**Wooten Engineering**

February 27, 2018

RE: Project Number 1004167 (17EPC-40043); Site Development Plan for Building Permit  
DRB Application addressing the Conditions of Approval

MASSING EXHIBIT

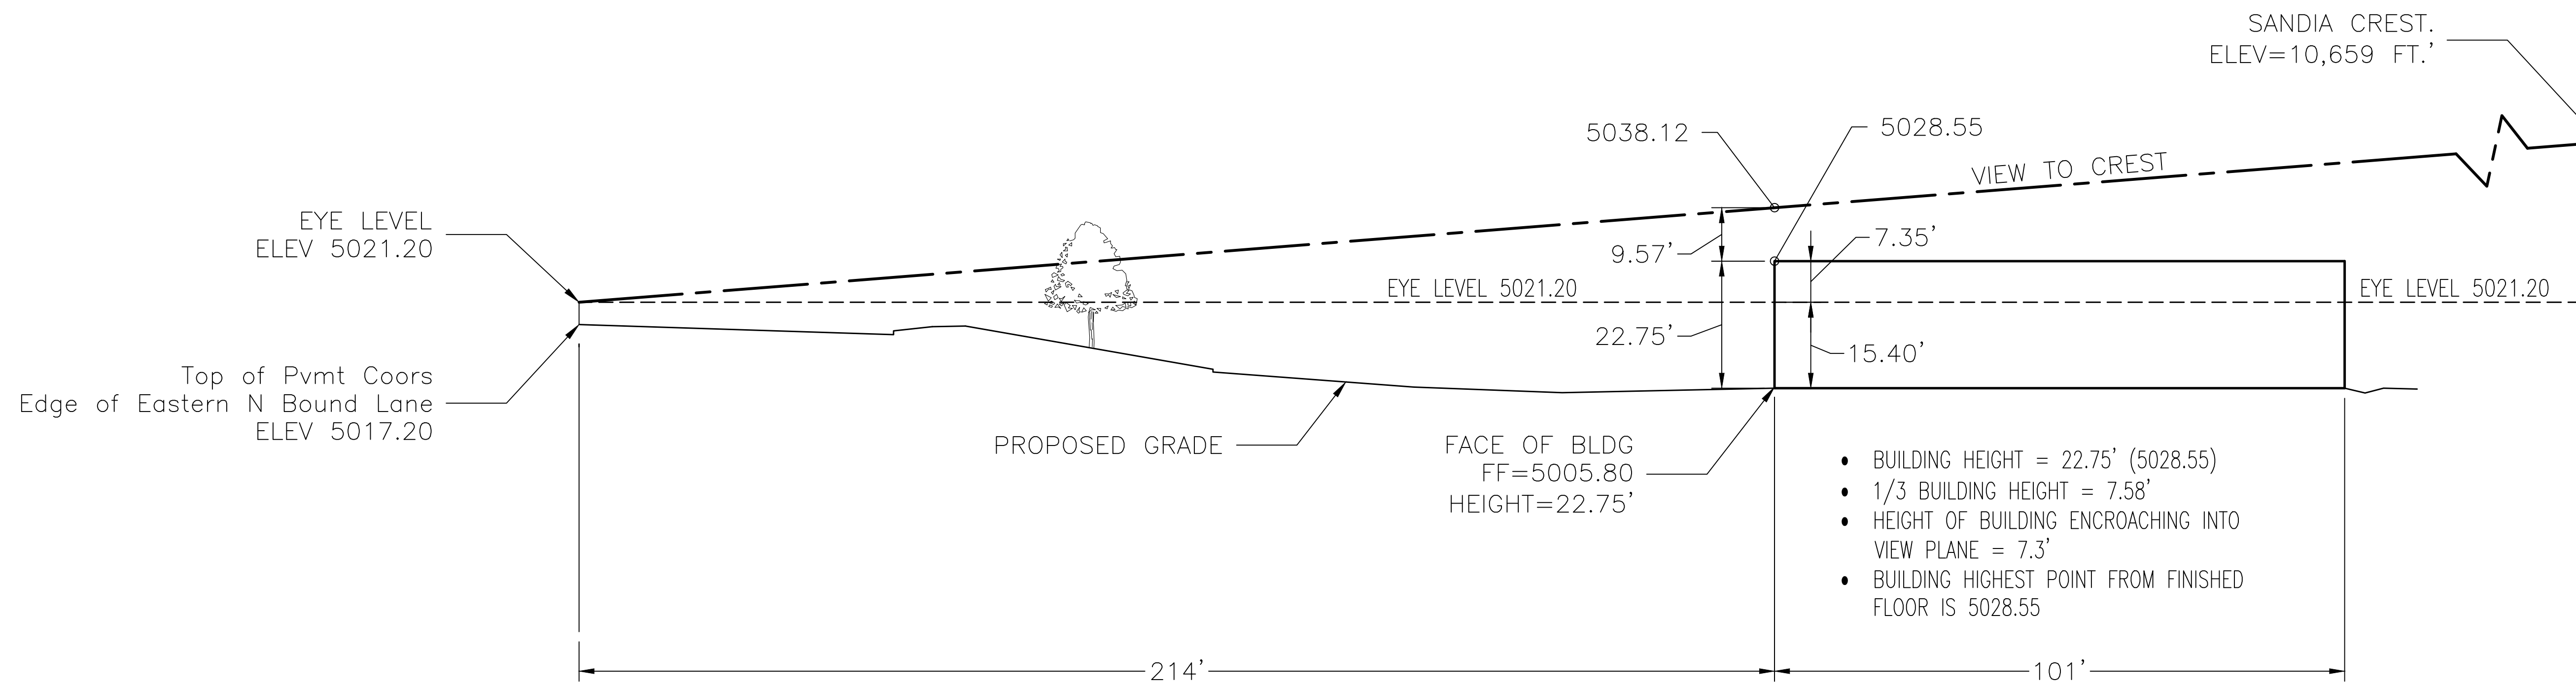
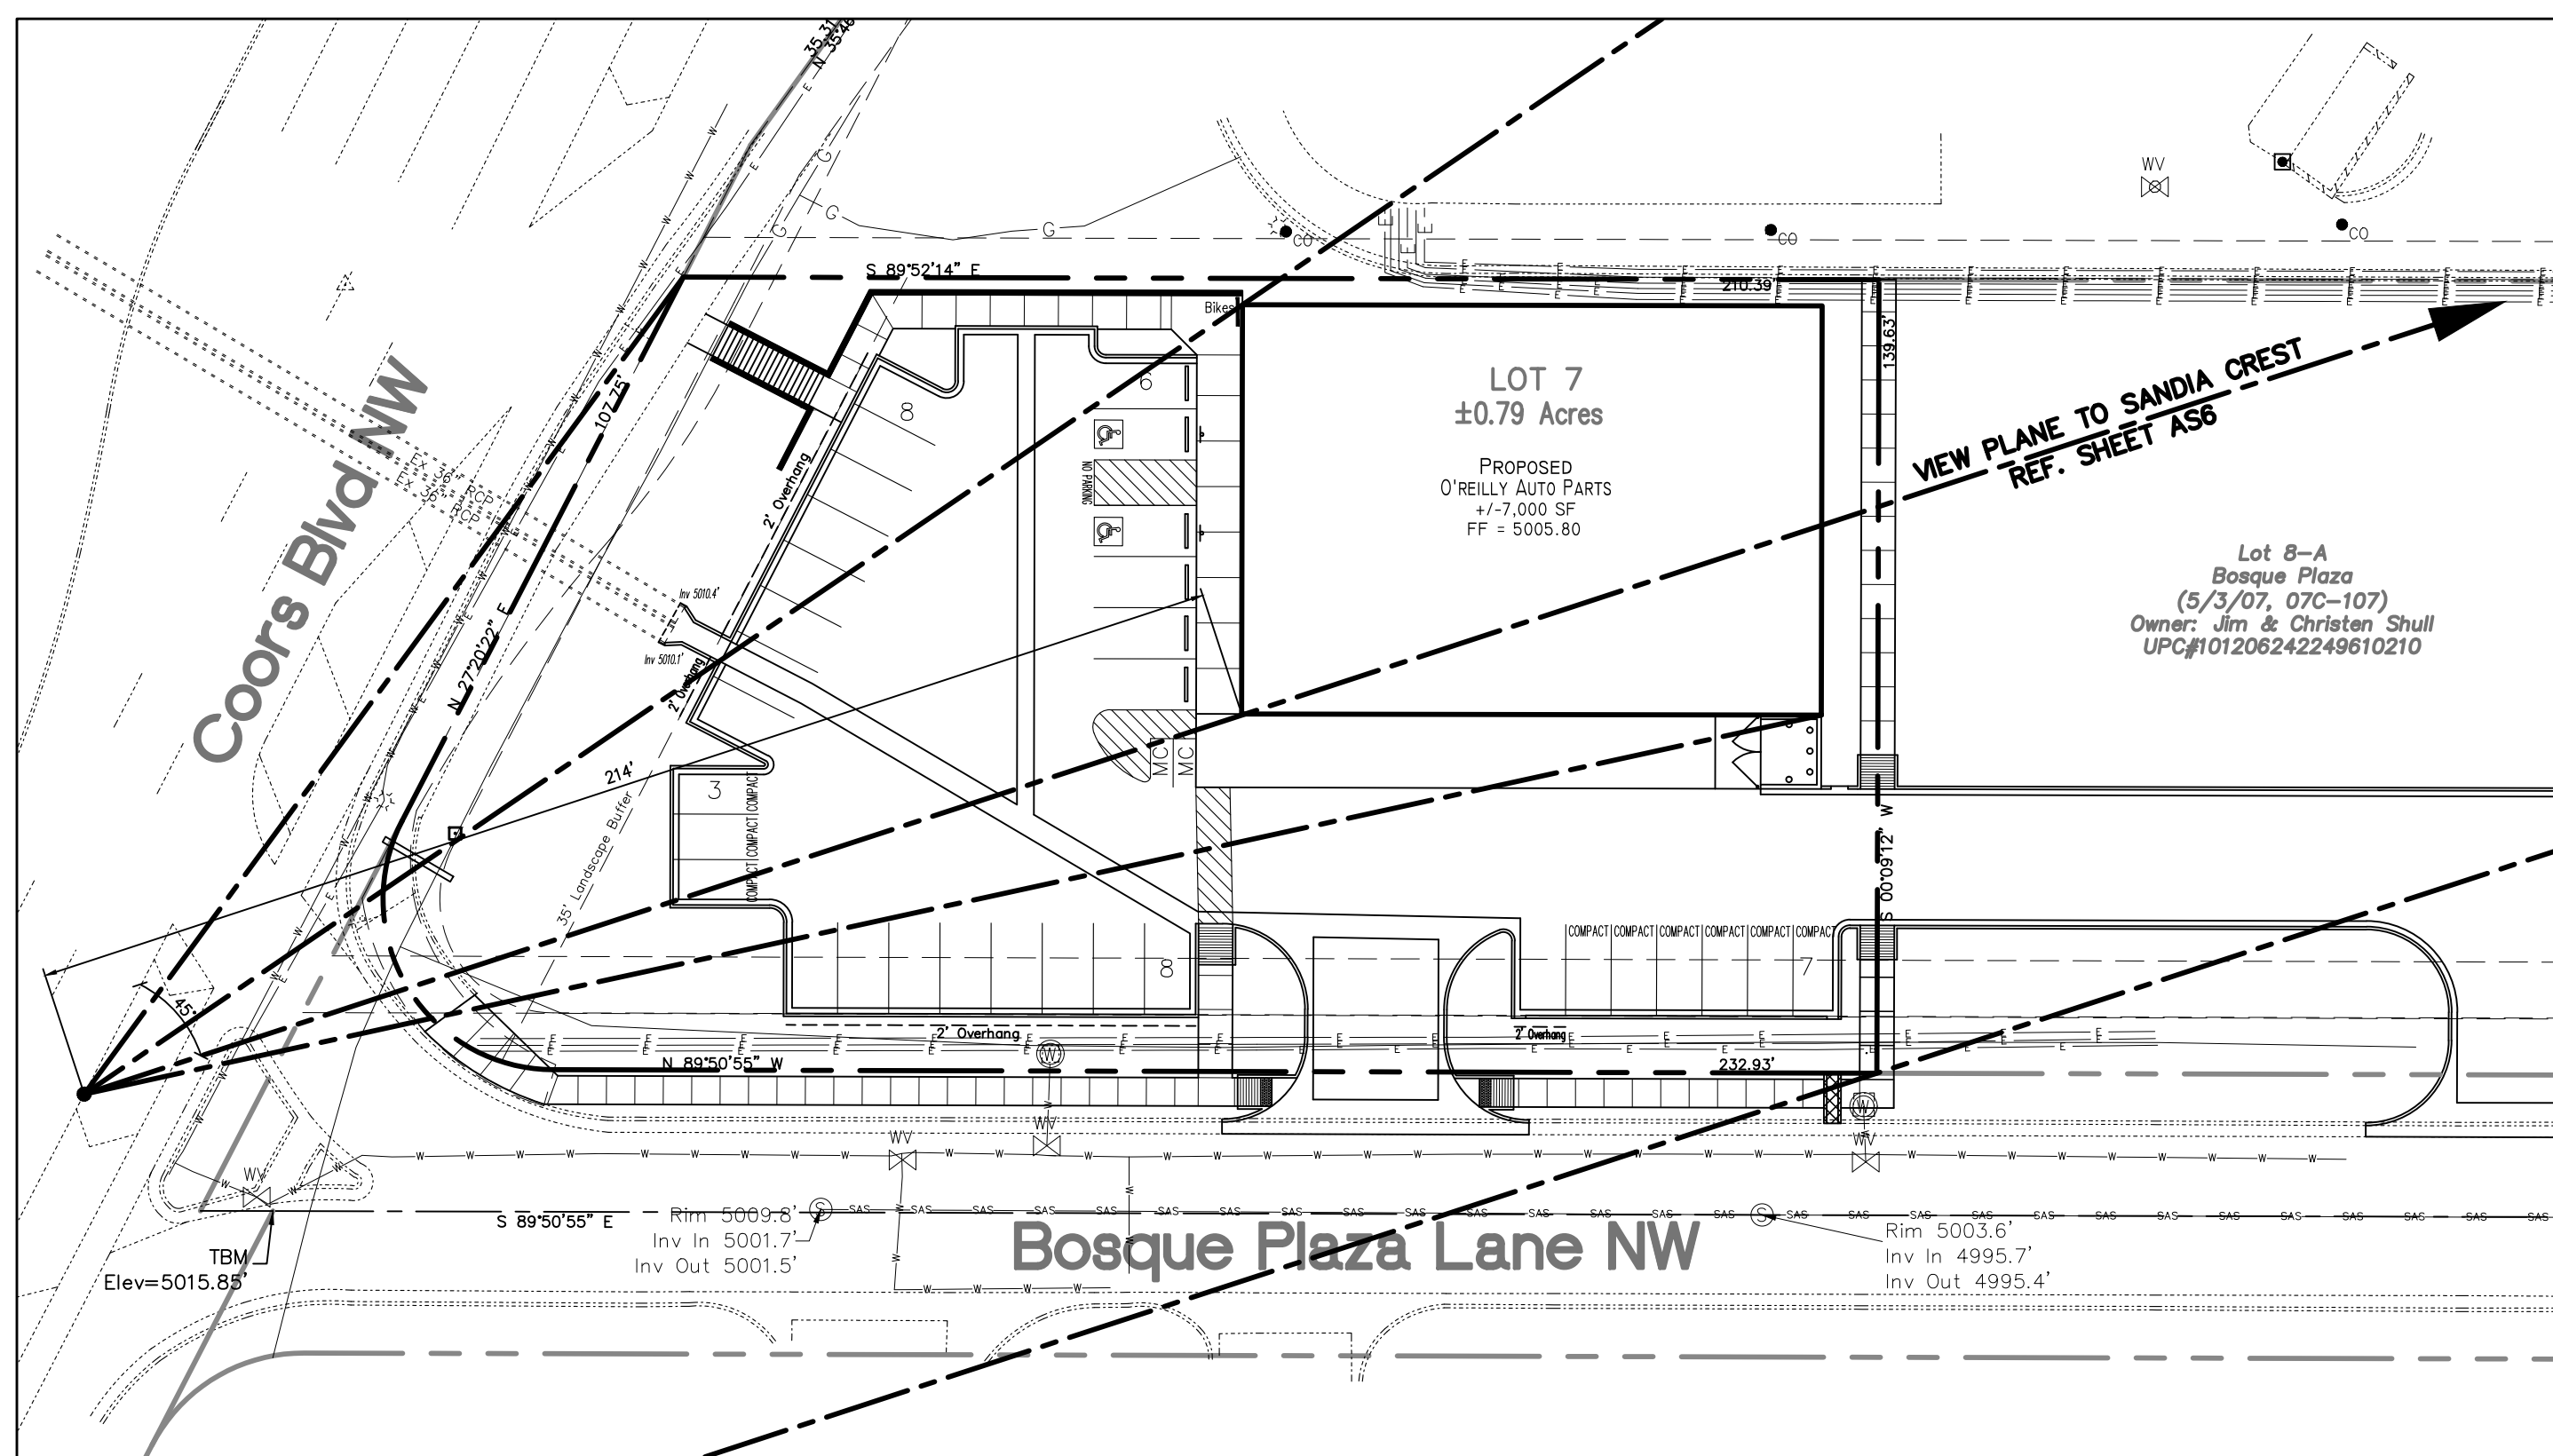
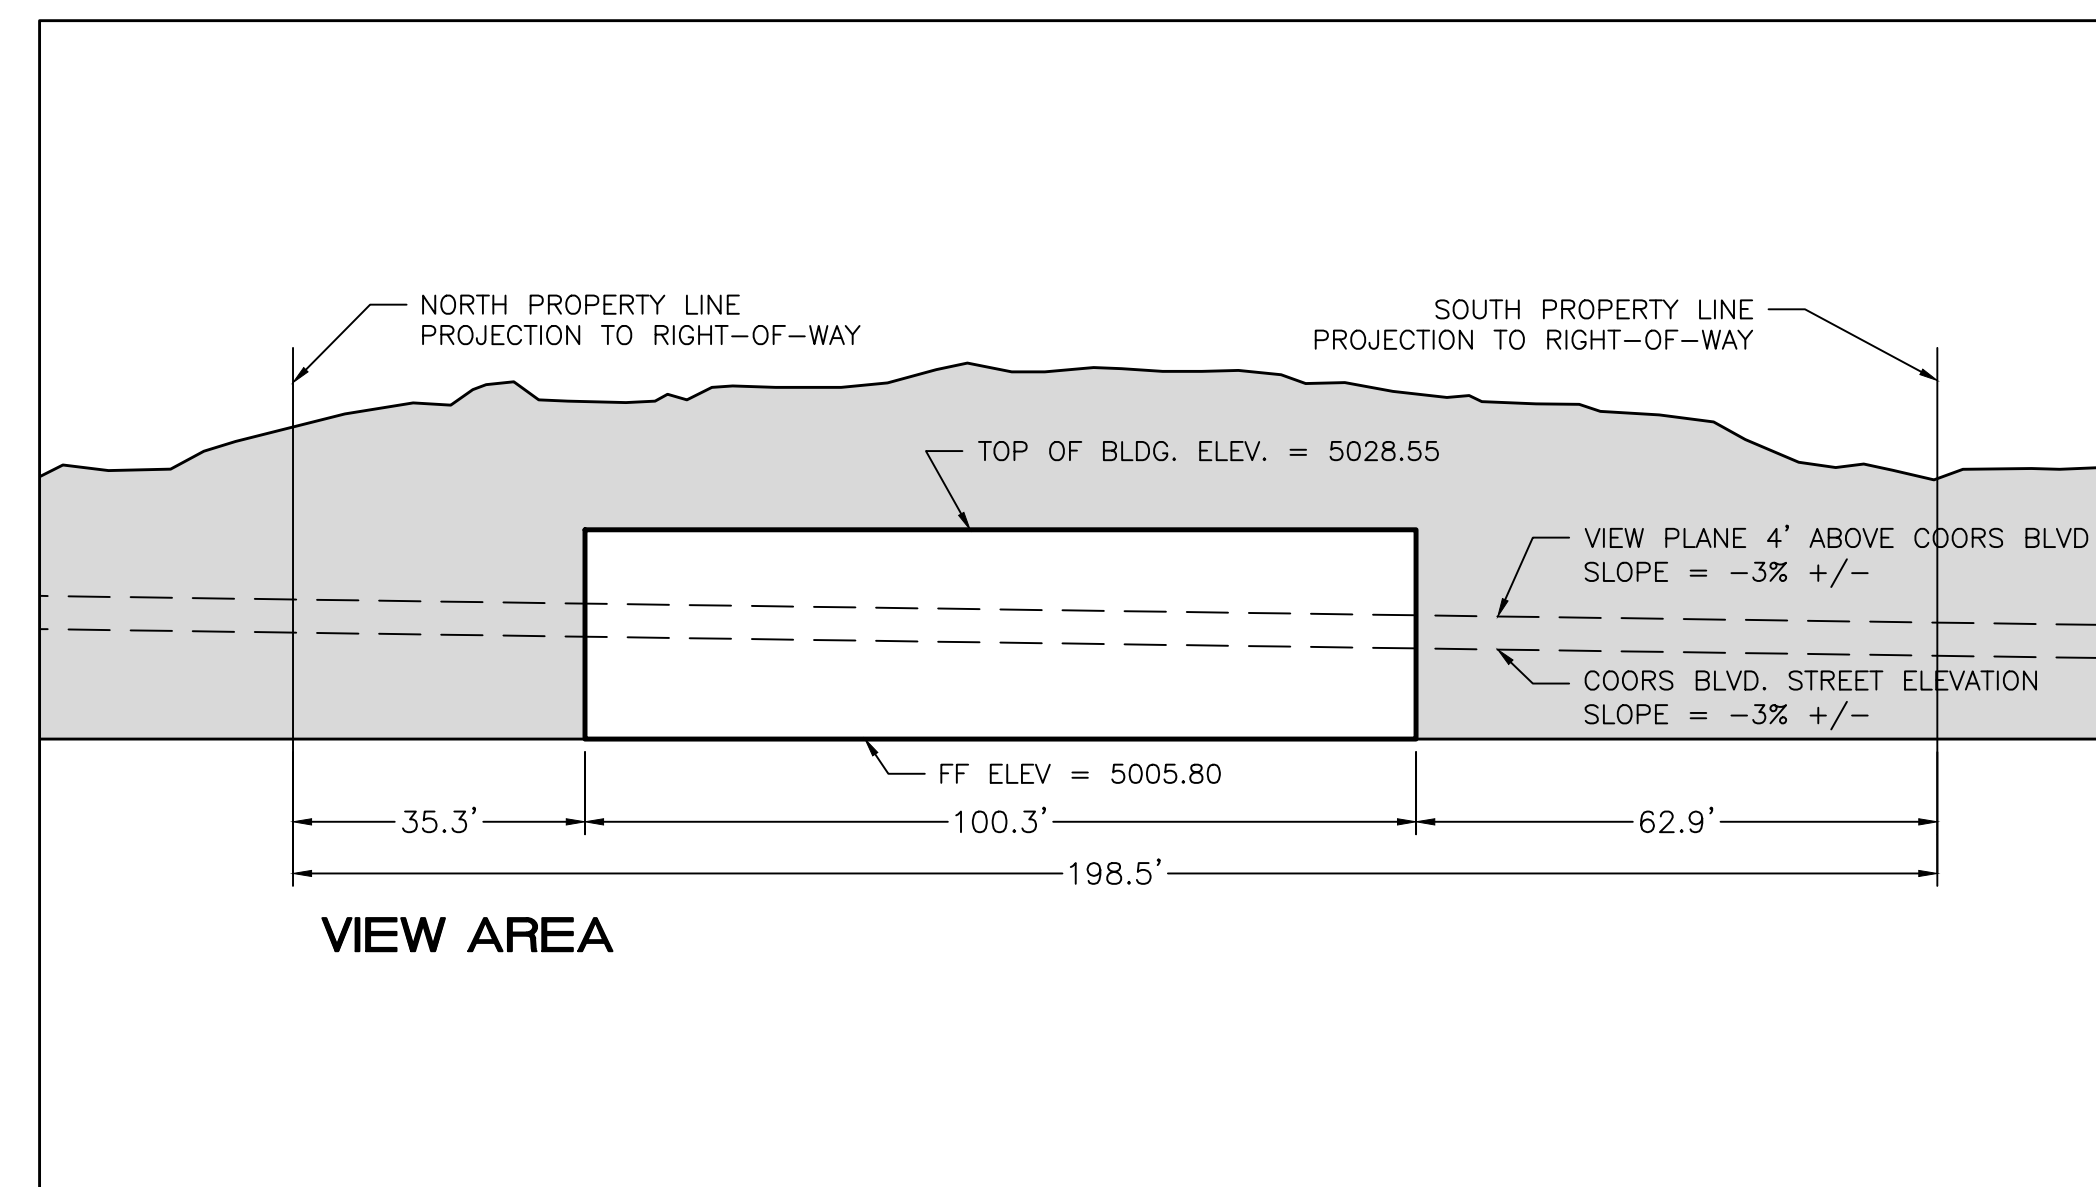
- C. The term View Area shall be used on the Massing Exhibit.  
**RESPONSE:** *The term was updated on the plan.*
  - D. The dimensions used in the Massing Exhibit shall correspond to the dimension on Sheet SP 1.1.

**RESPONSE:** *The dimensions have been updated.*
- 10. Signage
  - A. The Project Identification Sign shall be for the Bosque Plaza shopping center (Standard F-2-a and Sheet 1, signage note).
